From: [REDACTED]
To: [M42 Junction 6; Bartkowiak, Bart](#)
Subject: Philip O'Reilly - M42 Jct6 - Deadline 9 Submission
Date: 15 November 2019 23:16:36
Attachments: [Mr Philip O'Reilly - M42 Jct6 - Response to Highways England Deadline 8 Documents 8.93, 8.94 & 8.95.pdf](#)

Response to Highways England Deadline 8 Documents 8.93, 8.94 & 8.95:

8.94 Actions Arising out of ISH on dDCO 4 on 23 October for Deadline 8

**Traffic Regulation Measures Plans
Part 2 – Speed Limits**

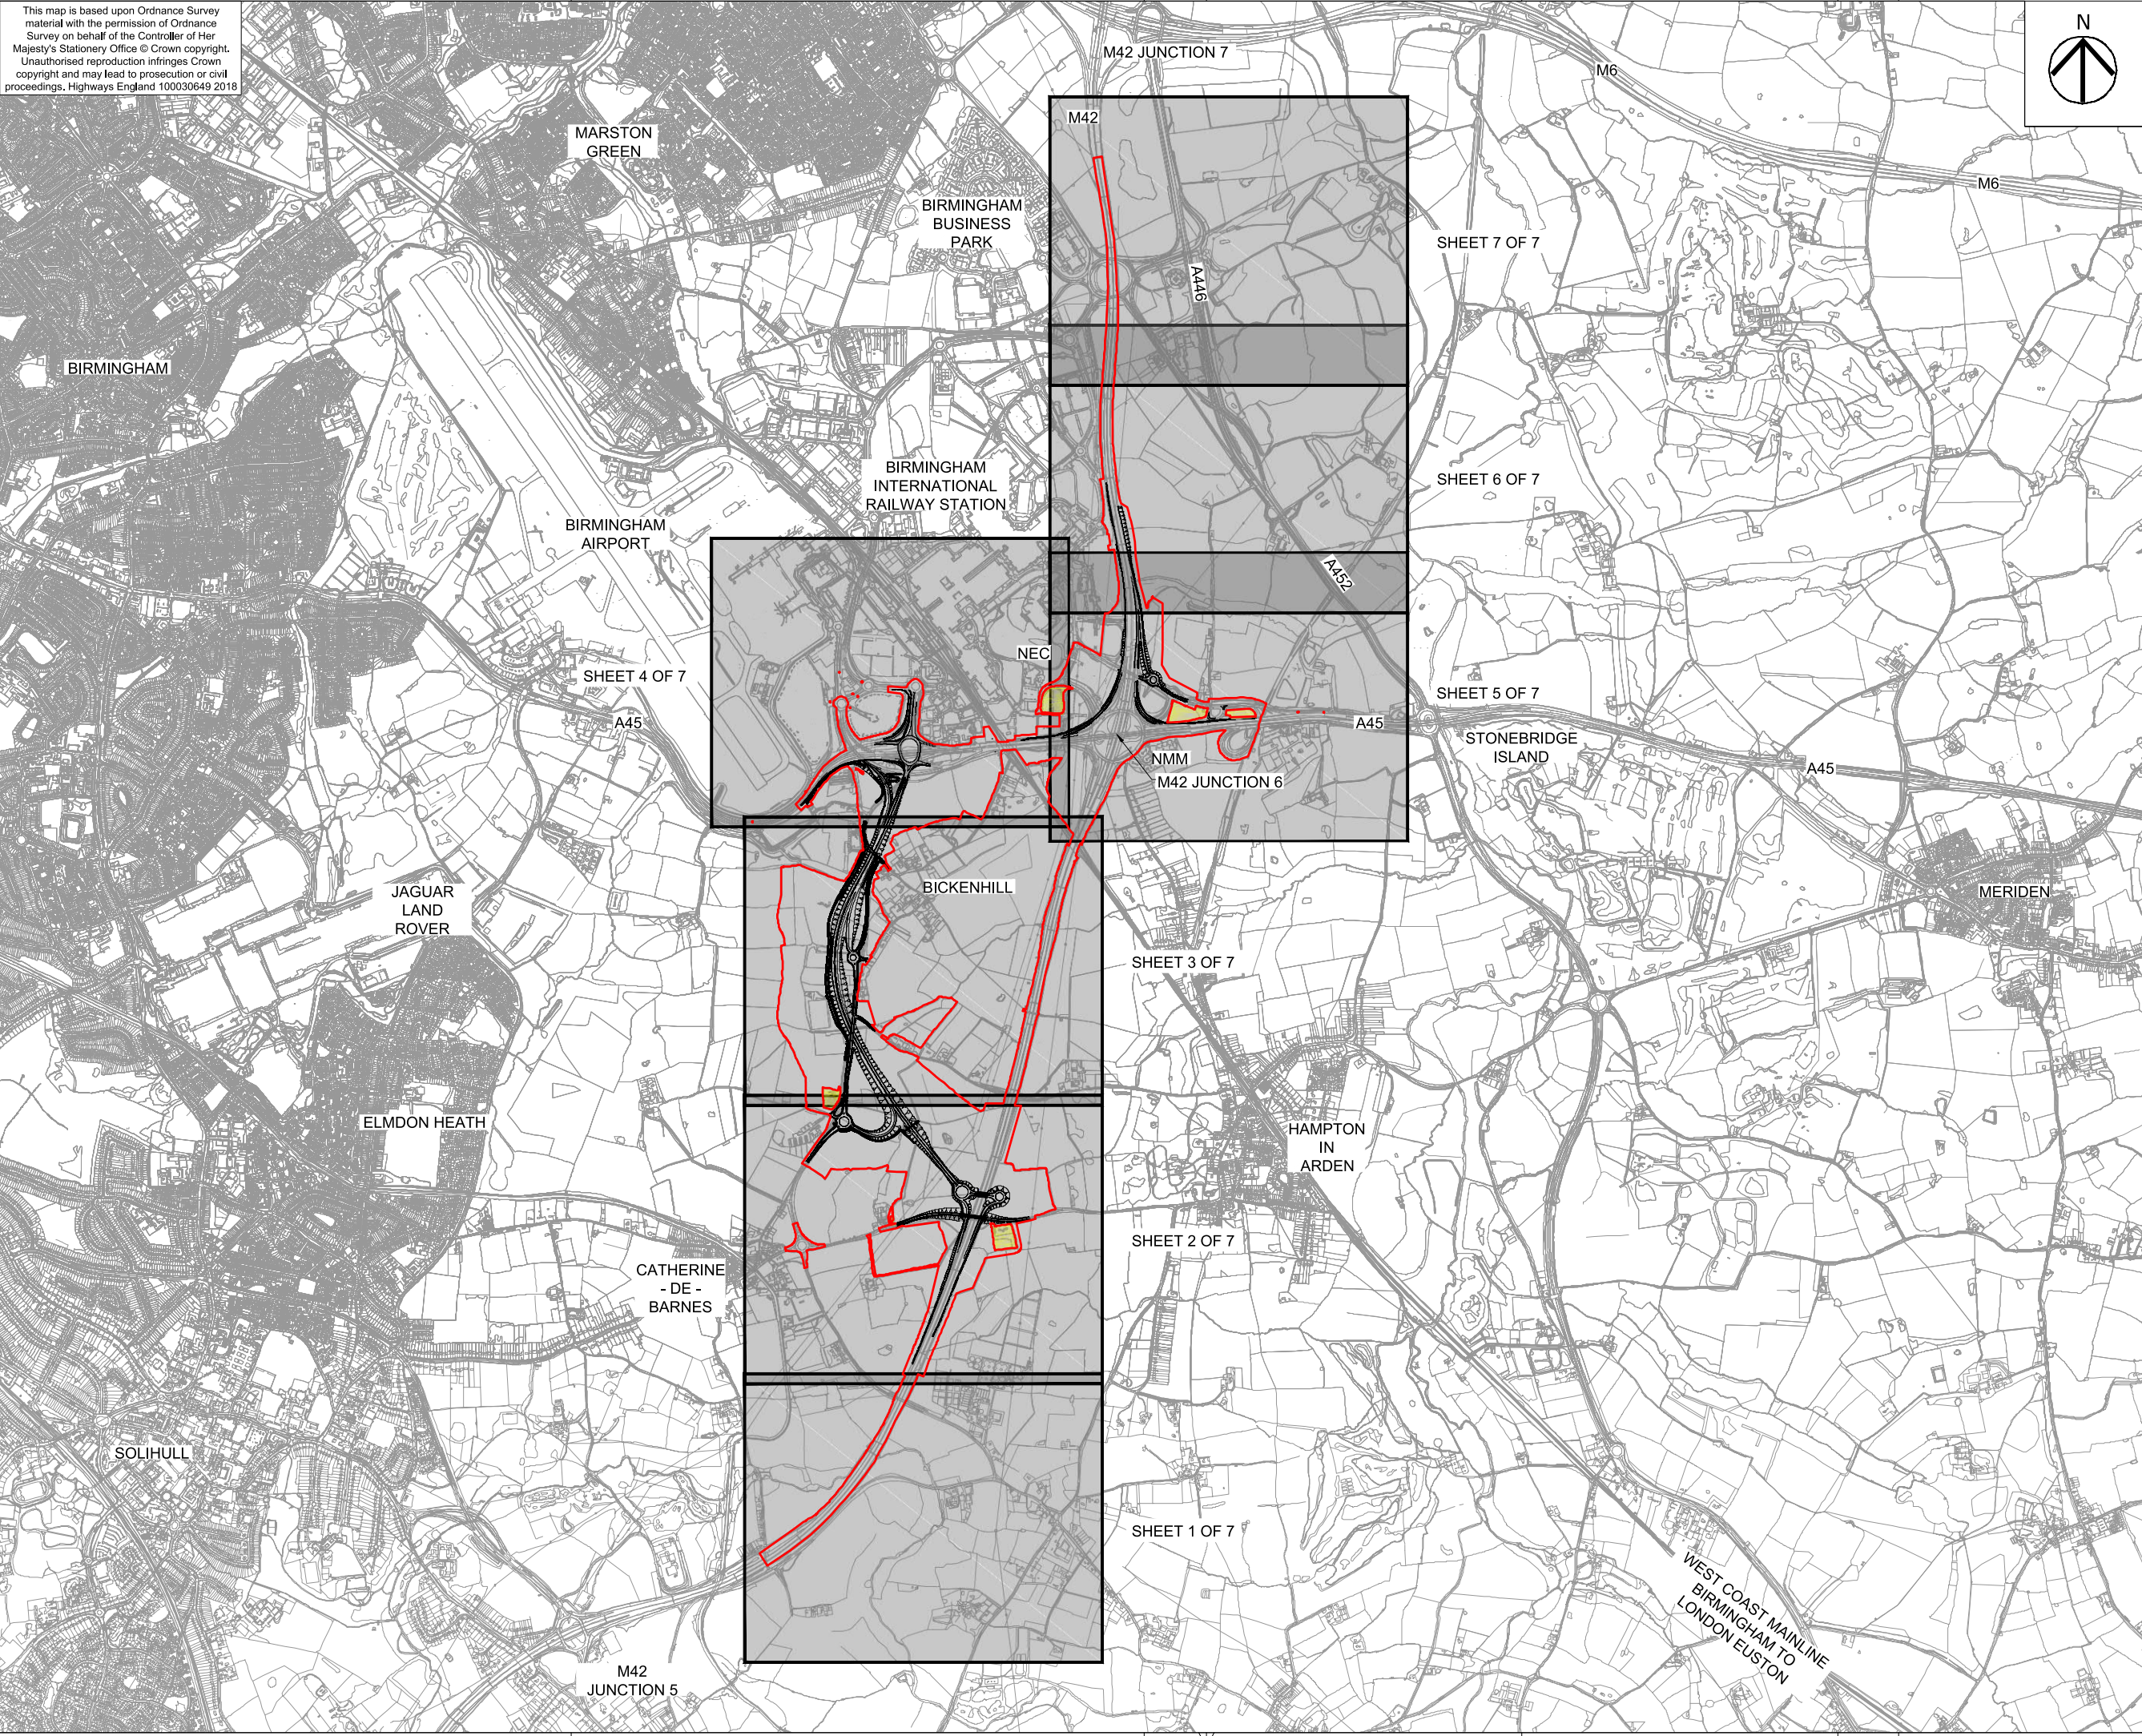
The following drawing is an extract from HE document 'TR010027-000099-TR010027_M42J6_2-6_Traffic_Regulation_Measures_Plans_Speed_Limits' (sheet 2 of 7), submitted with the original DCO application in January 2019:

In terms of roundabout size, the roundabout is now proposed to be 220m rather than 240m.

The roundabout alignment is not significantly different.

The design speeds have not changed.

HE repeatedly stated that the total length of Barber's Coppice roundabout and its approaches was 740m. They now say it has only changed as a result of design changes.

If it was solely down to design changes, the revised length would be $740\text{m} - 20\text{m} = 720\text{m}$. It isn't.
